**Our ref:** RA/2023/145899/03-L01  
**Your ref:** 2023/91441

**Date:** 08 July 2024

**CHANGE OF USE AND ALTERATIONS TO FORMER CHURCH (B8-STORAGE) TO 9 RESIDENTIAL UNITS (C3) AND FORMATION OF CAR PARK (LISTED BUILDING WITHIN A CONSERVATION AREA) – 31 CHAPEL HILL, LINTHWAITE, HUDDERSFIELD, HD7 5NJ**

**Environment Agency position**

**Drawing:**  
 Proposed  
 Site Plan

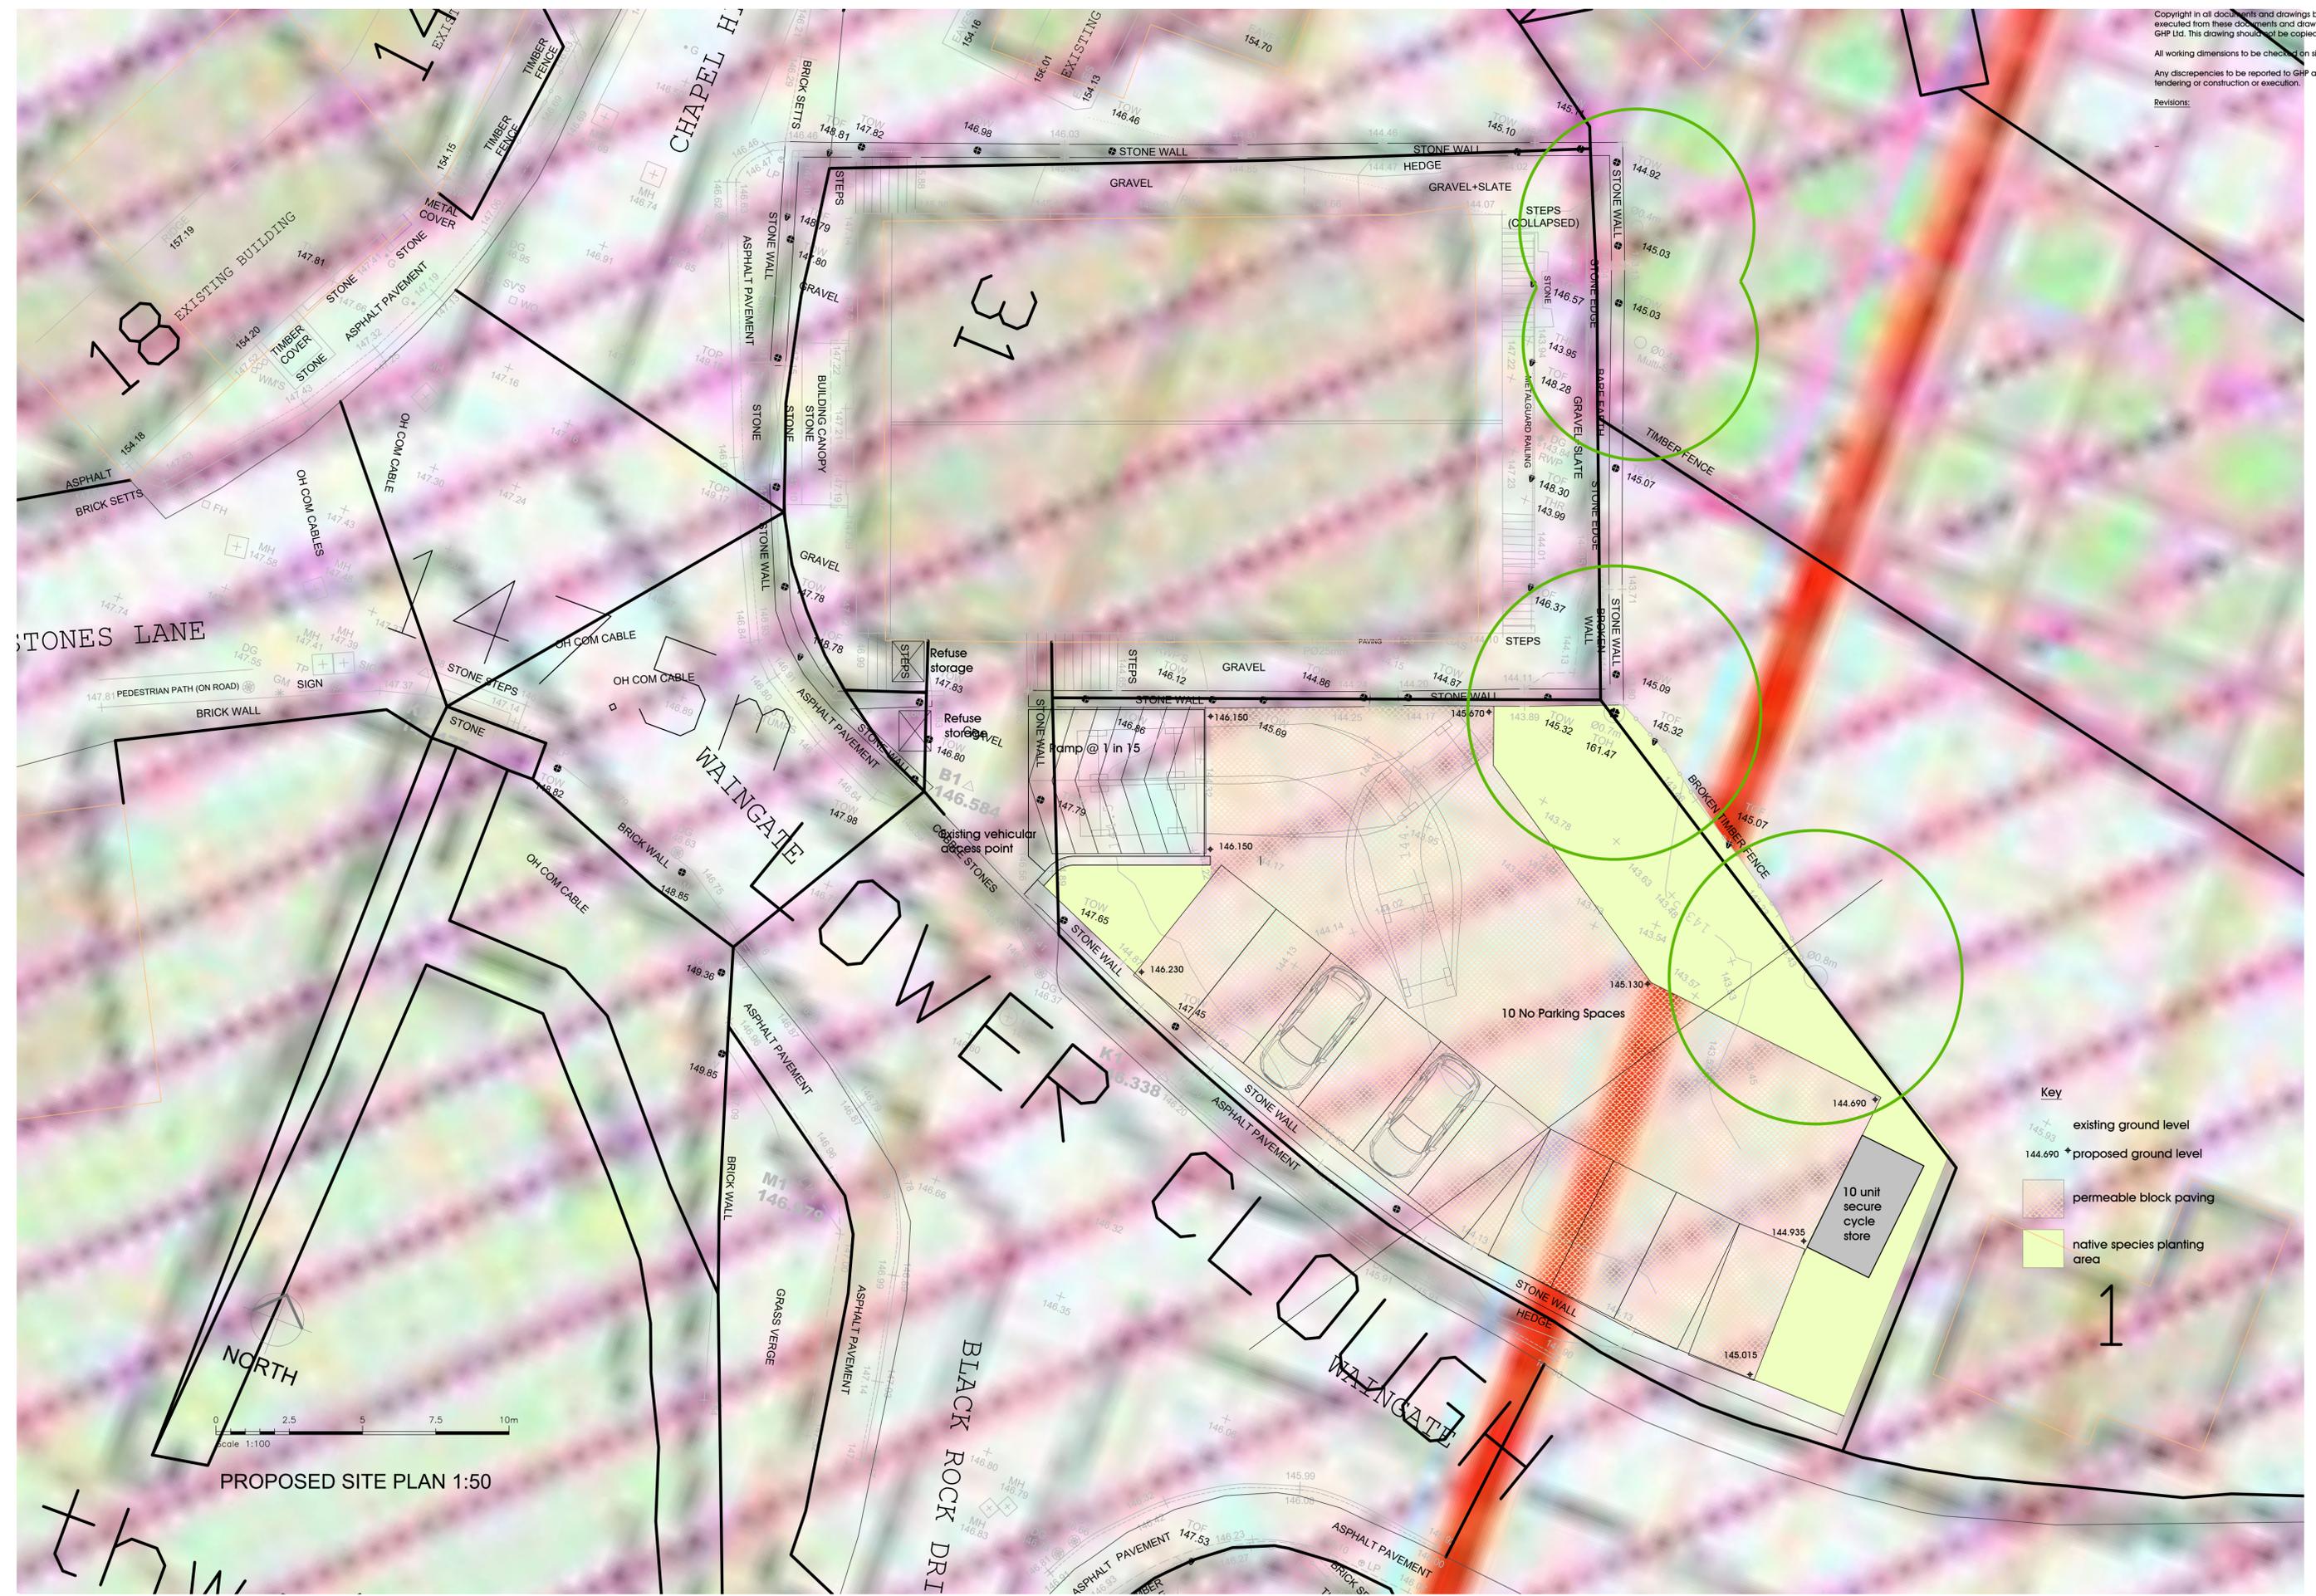
We maintain our objection to this application as it involves building near a culverted main river. As submitted, it is unlikely that we would grant a flood risk activity permit for this application.

The proposed development may adversely affect the construction and stability of the culvert which will compromise its function. The proposal could therefore increase the risk of flooding to surrounding communities, including Linthwaite. We note the justification for not opening the culvert in this location and accept this.

We note that photographs of the inside of the culvert have been provided, however there is no further assessment, structure analysis and/or load calculations to support the application.

Further evidence must be provided to demonstrate that the proposed development will have no impact on the structural stability of the culvert. A CCTV report, or similar, of the culvert interior should be carried out to prove the culvert integrity is constant for the length of the site. Should this identify any further works needed to the culvert, further structural integrity assessments and calculations shall be provided, alongside a plan for reconditioning the culvert.
